DECISION DELEGATED TO HEAD OF PLANNING

Application No: H09-0175-22 **Applicant:** Mr & Mrs S Hill
Proposal: Proposed two storey side extension
Location: 5 Huntingdon Close Holbeach Spalding
Terminal Date: 12th April 2022

Proposed Front (North-East)  
Elevation

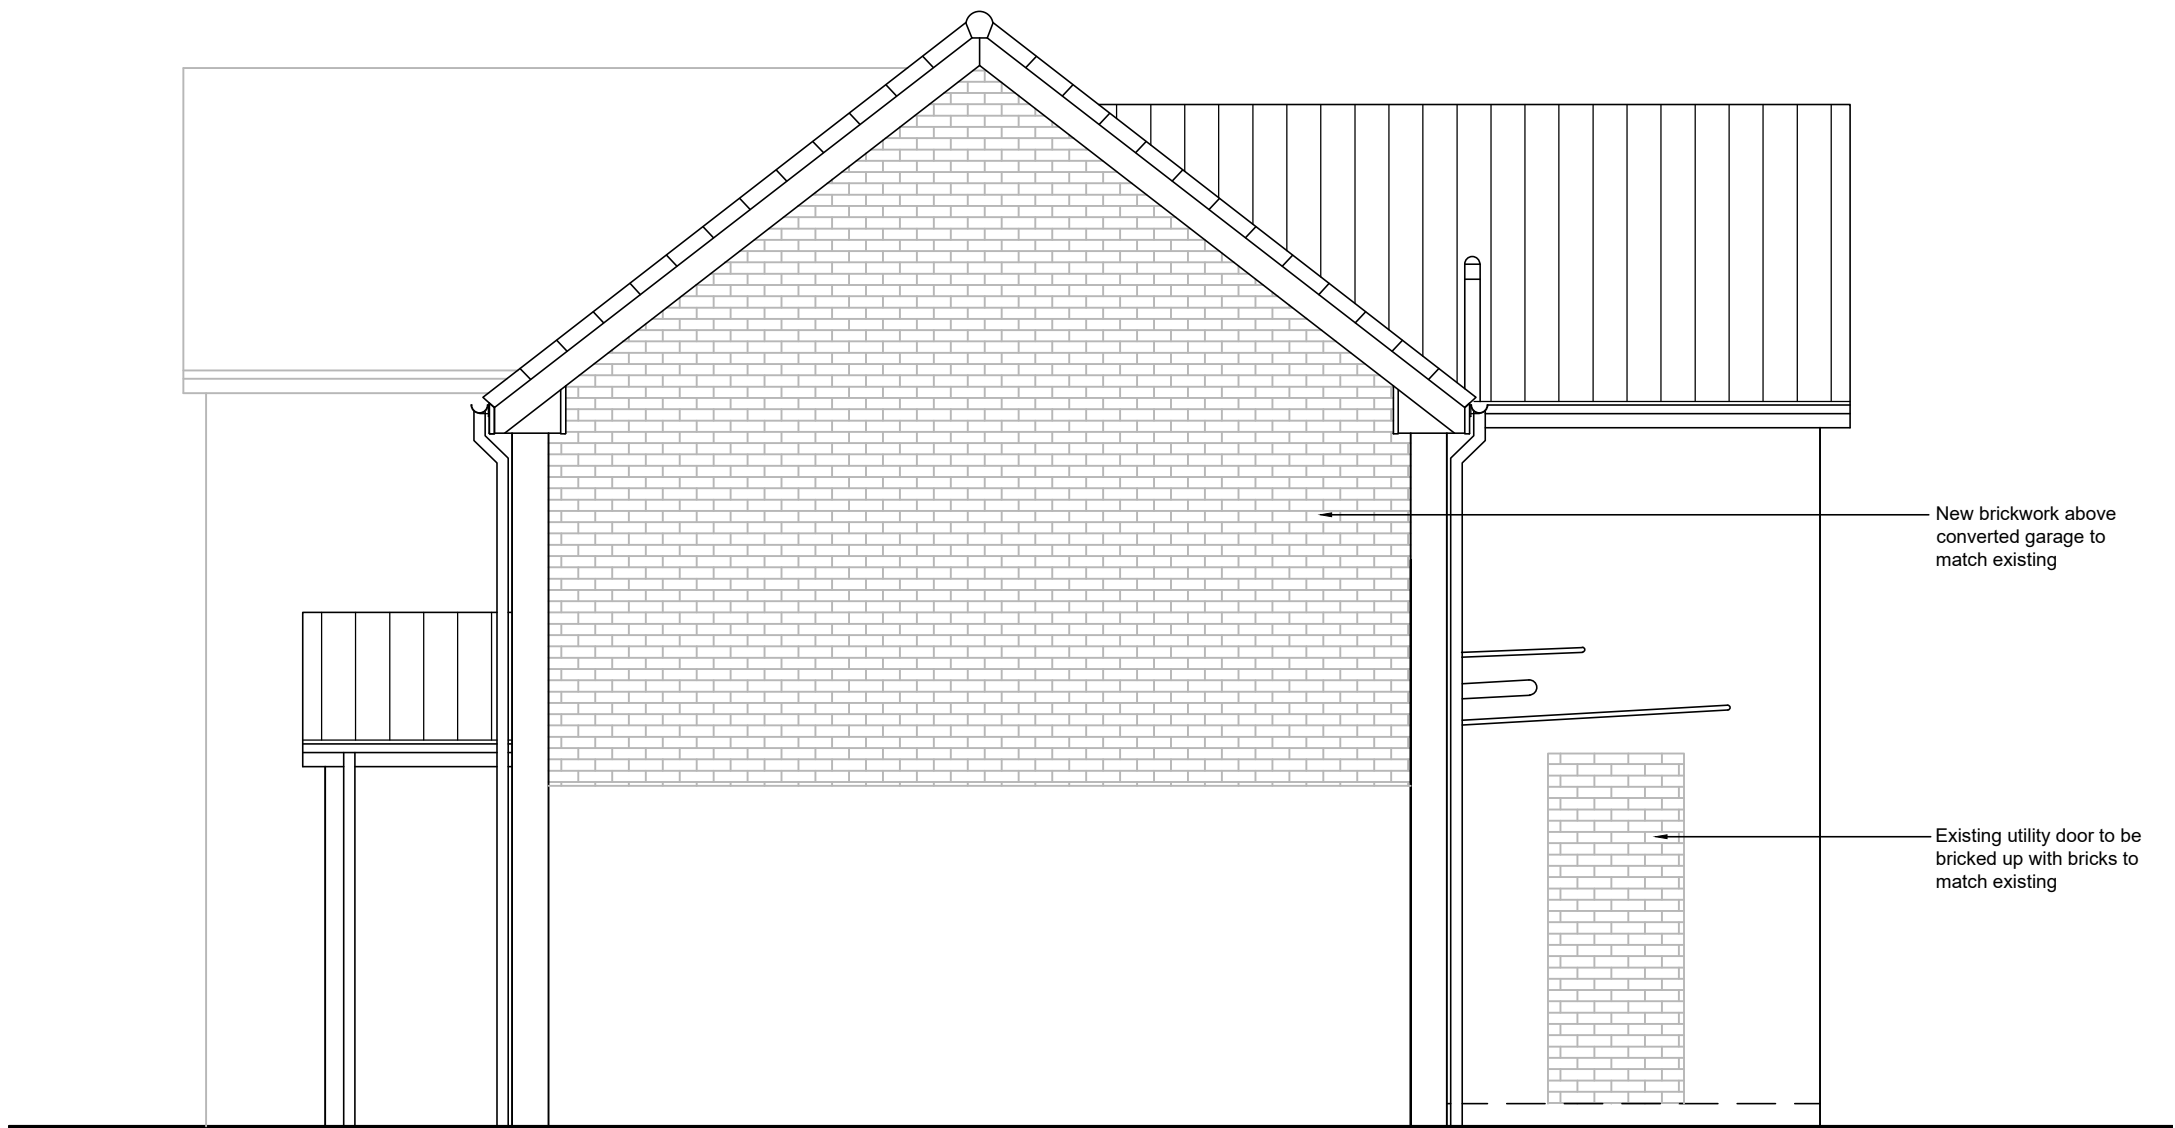
The proposed two storey side extension is considered to be proportionate to the existing dwelling and the plot. Its design with the roof following the shape of the existing roofline would respect the design of the existing dwelling. Although a lowered roof ridge is usually required for side extensions, in this instance a flush finish can be accepted given it would not result in a terracing effect. The extension is not considered to appear unduly incongruous within the rural street scene and would not materially harm the character/appearance of the locality. The extension would not extend beyond the front/rear elevations of the existing dwelling therefore there would be an element of subservience. The proposed use of matching external materials would ensure the extension is in keeping with the existing dwelling.

The closest neighbour is the attached neighbour at no.4 Huntingdon Close. The proposed extension would not be visible to this neighbour as it would not extend beyond the front/rear elevations of the applicants existing two storey dwelling and would therefore be blocked by this. As such no unacceptable impact would result on this neighbour.

The only other immediate neighbour is no.6 Huntingdon Close located to the north-east of the application site. The proposed extension would be sited some 11 metres from this neighbours boundary and approximately 15 metres from its nearest elevation. Given the relationship with this neighbour this separation distance is considered sufficient as to not result in any overbearing impact, overlooking or unacceptable overshadowing.
